Riverview House, Uxbridge

Class 0 Change of Use Application

Project Title:	Riverview House, Uxbridge
Project Ref:	1153
Report Title:	Class 0 Change of Use Application
Report Ref:	P931
Revision:	0
Date of Issue:	September 2022
Purpose of Issue:	Information
Compiled By:	Beatriz Antuna Tentor
Reviewed By:	Ben Paterson
Review Date:	12-09-22
File Location:	-

TPM Studio have been asked on behalf of Permitted Developments Investments No. 7 Ltd to prepare and submit a statement in support of the Section 73 Application relating to the proposed redevelopment of Riverview House in Uxbridge.

Project Title: RIVERVIEW HOUSE, UXBRIDGE
Project Ref: 1153
Status: PLANNING
Scale: 1:100 / A1
Sheet Title: GA PROPOSED SECOND FLOOR PLAN
Sheet Ref: P132 / 0

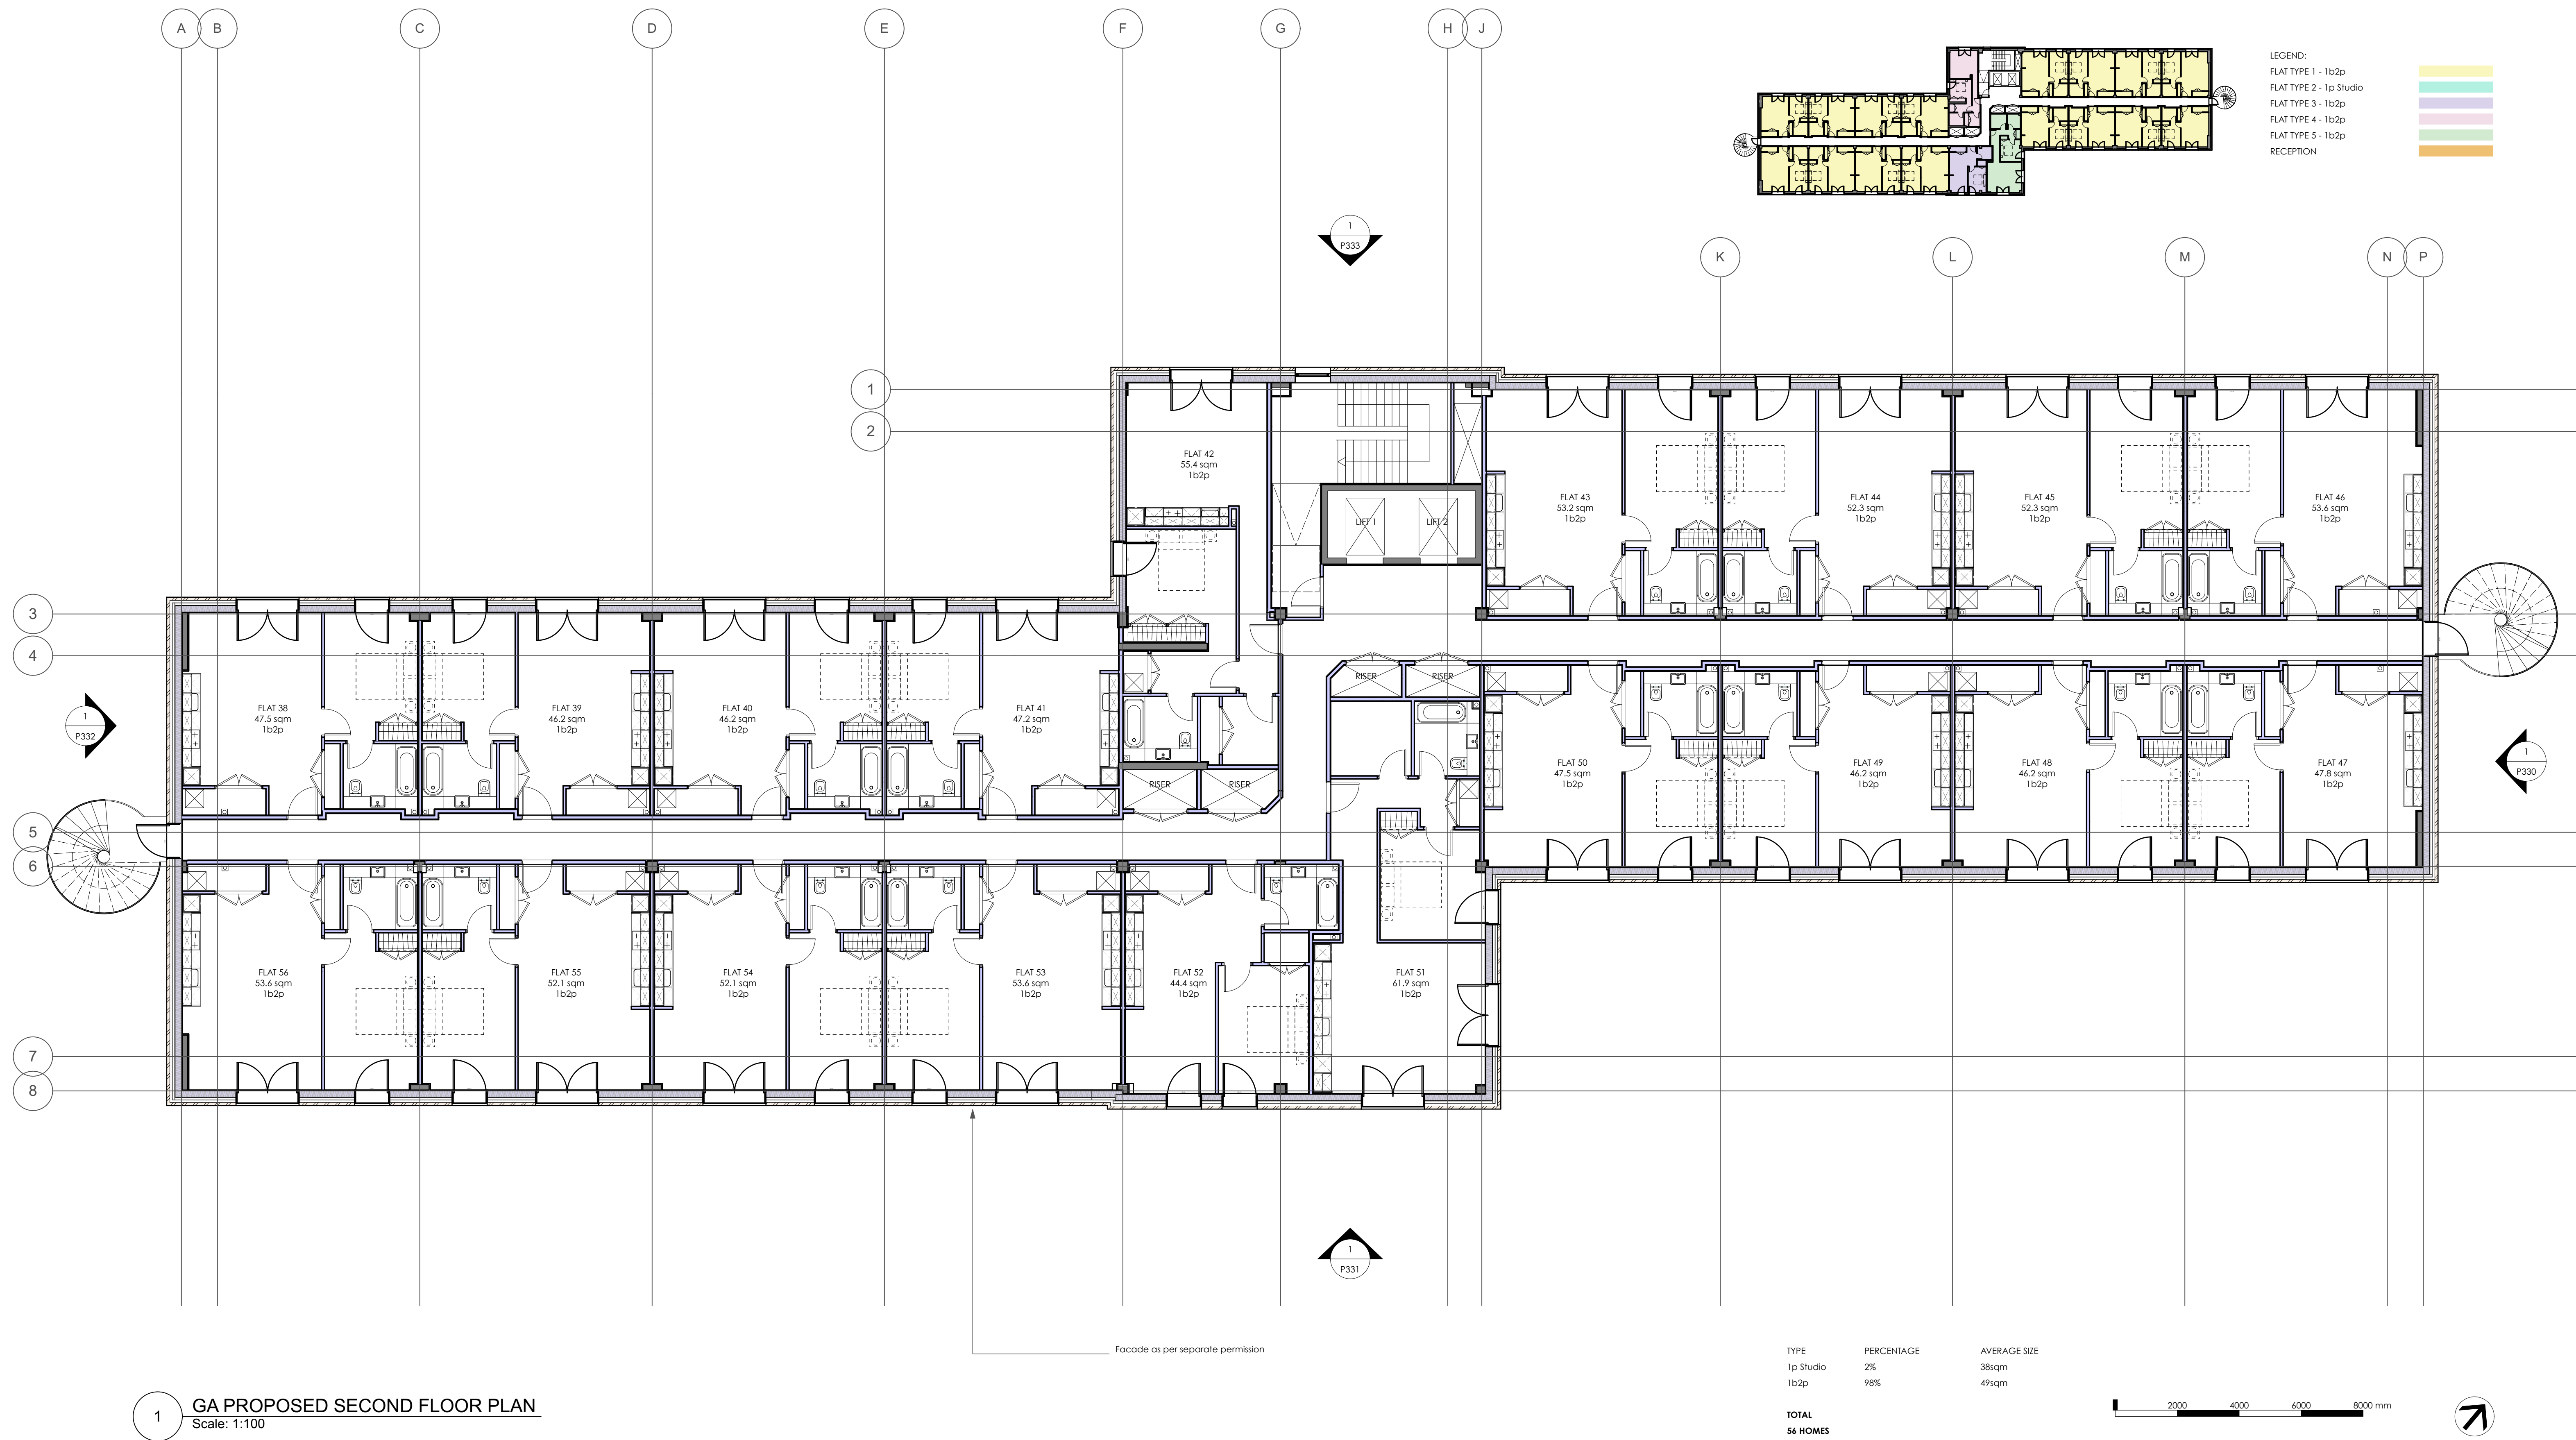
- The arrangement of apartments on the first and second floors are consistent with the consented scheme where the predominant changes occur along the internal wall of apartments where the width of the corridor has narrowed slightly to allow for generally 1200mm clear wall-to-wall, with passing spaces 1500mm in width. The naming conventions of the individual apartments is consistent with the NDSS and the previous application.

- Inclusion of a localised ramp adjacent to the lift core and between the stair landing and the lift lobby. The ramp allows for level differences between the slab and stair landing.

- Minor internal modifications of apartments to create improved, more open plan living accommodation, with better access to storage.
- Rationalised arrangement of bathrooms and coordination of services between the ground and fourth floors.

- Modification of Apartment 23/42 (left-hand side of the stair core) owing to the position of the existing primary structural fin walls which cannot be removed.

- To the north and east elevations, where windows where previously not identified on plan these are now captured.
- Inclusion of risers where these were previously missed of the arrangement plan.

- Modification of the internal layout of apartment 32/51, following changes to the arrangement of the service risers.
